Please ask for: Nicola Moore
Email: nicola.moore@arun.gov.uk
Telephone: Ext 37944
Our Ref: AW/48/21/HH
Your Ref:
Date: 15th February 2021

Application for Planning Permission for Works or Extension to a Dwelling

Development: Roof alterations to provide extension to existing first floor and swimming pool in rear garden
Location: 17 Kingsway Aldwick PO21 4DQ

roof plan
1 : 200

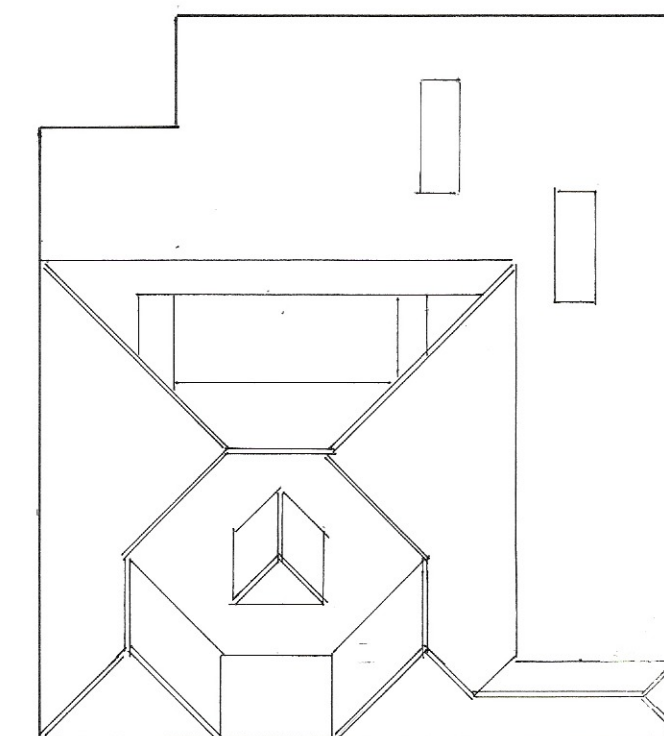
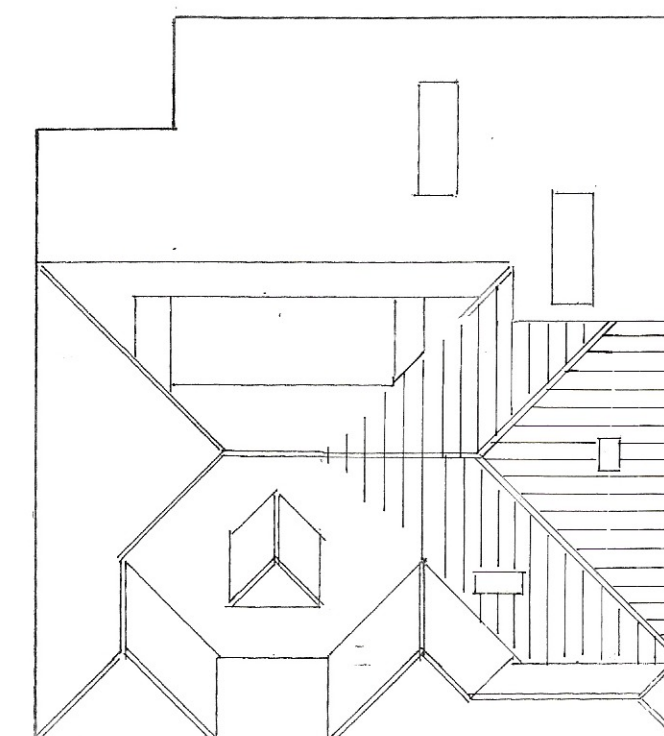
Roof Plan

Please submit 1 electronic or 3 paper copies of existing and proposed roof plan. Please refer to the Validation Requirements List for further details.
